National Infrastructure Planning  
Temple Quay House  
2 The Square  
Bristol, BS1 6PN

Our Ref: EN010127

### **Application by Mallard Pass Solar Farm Limited for an Order Granting Development Consent for the Mallard Pass Solar Project**

#### **Advice following issue of decision to accept the application for examination**

Location, Order Limits and Grid Coordinates Plans

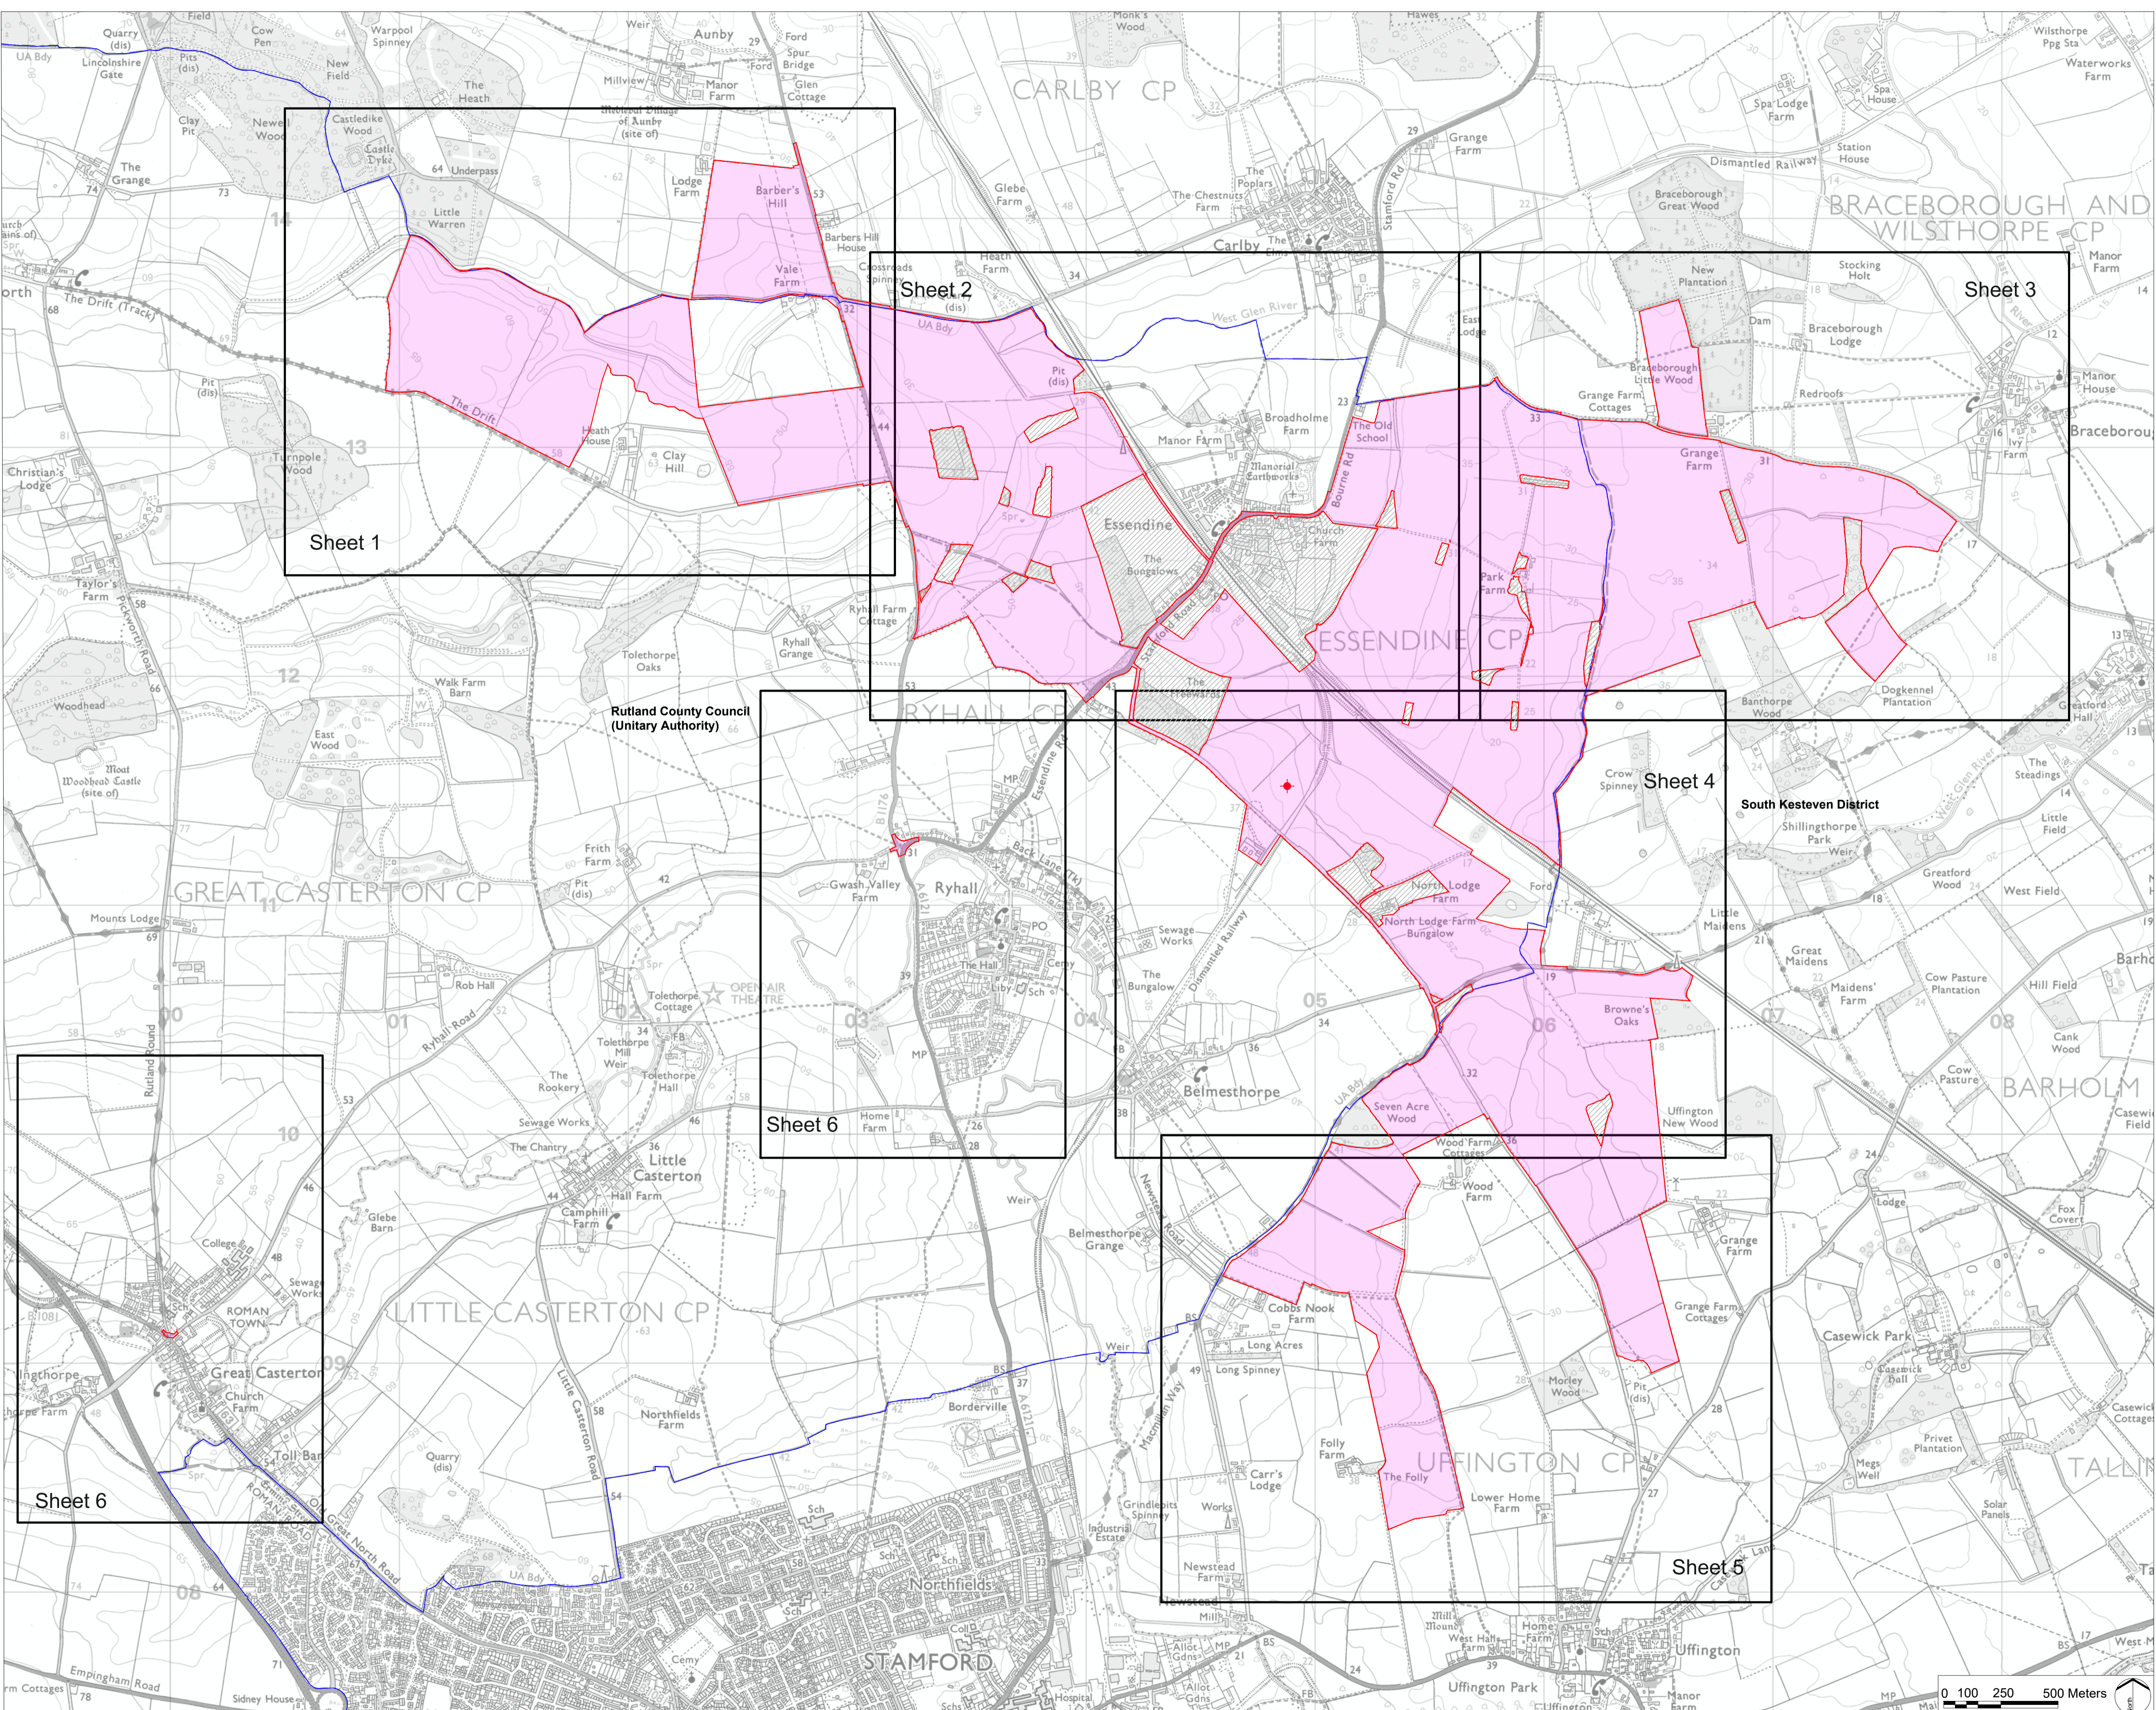
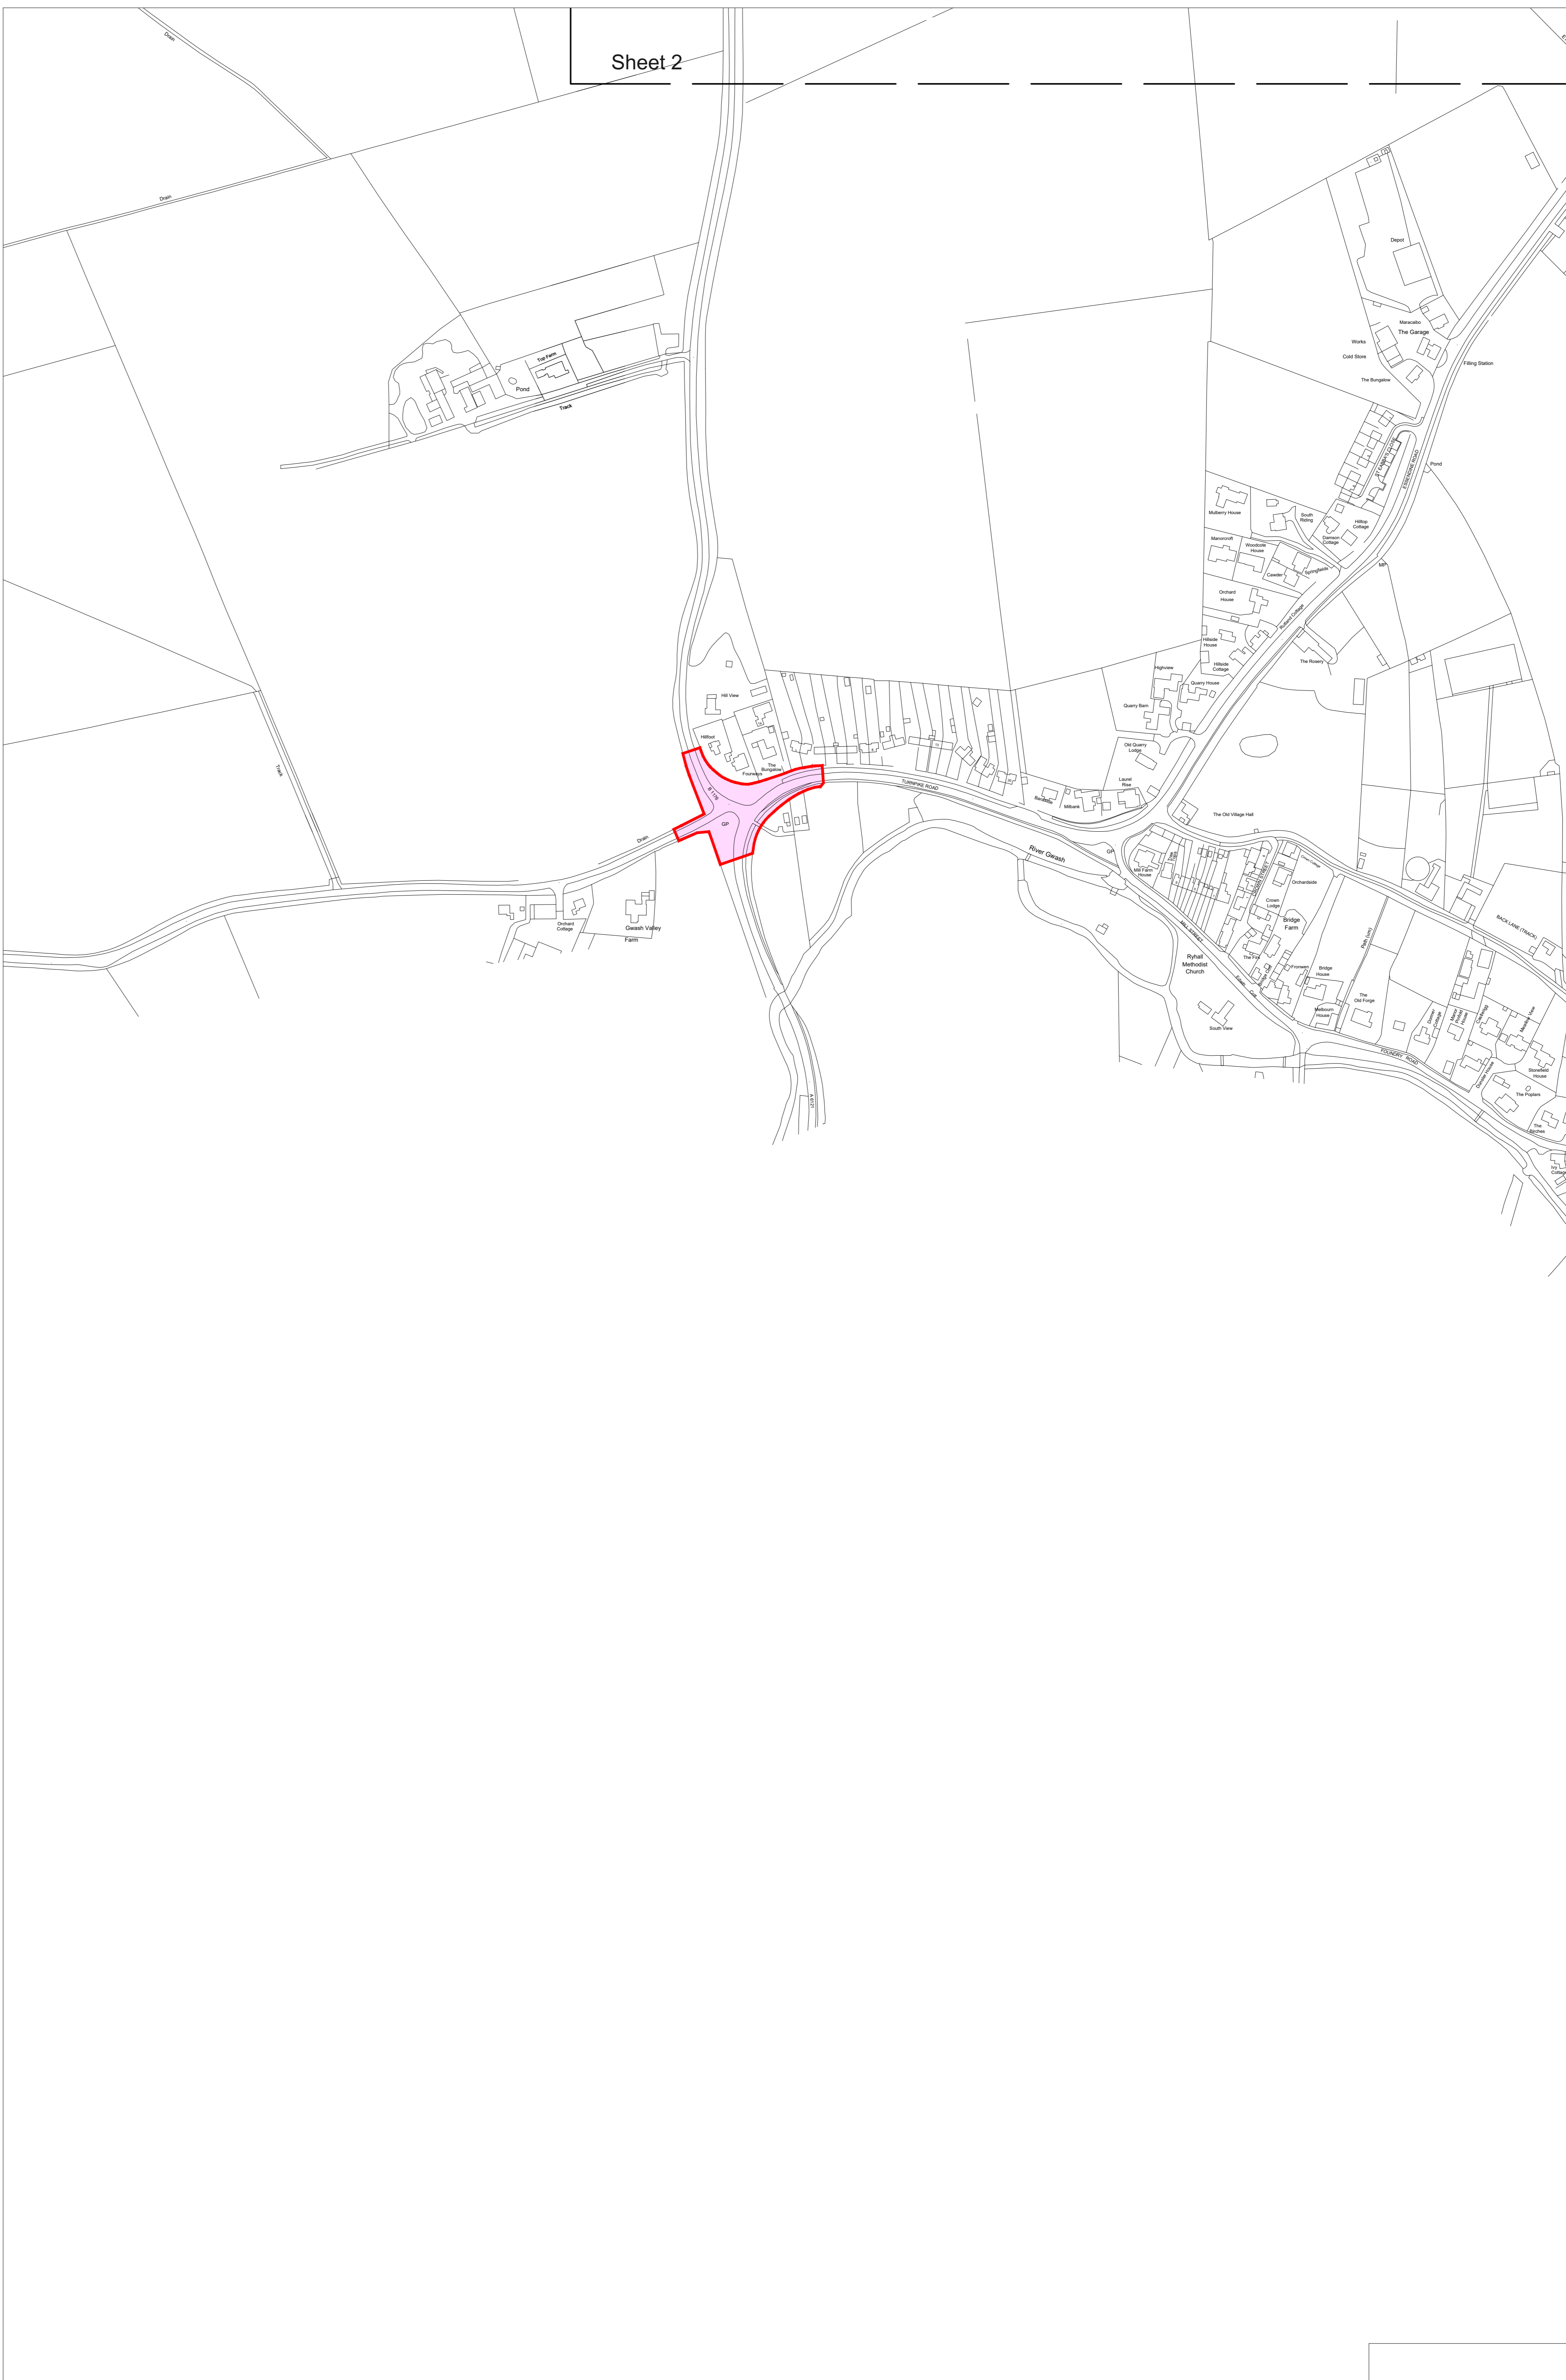
Sheets 1 and 3 are missing areas which, albeit outside of the Order limits, are close enough to the Order limits to warrant inclusion.
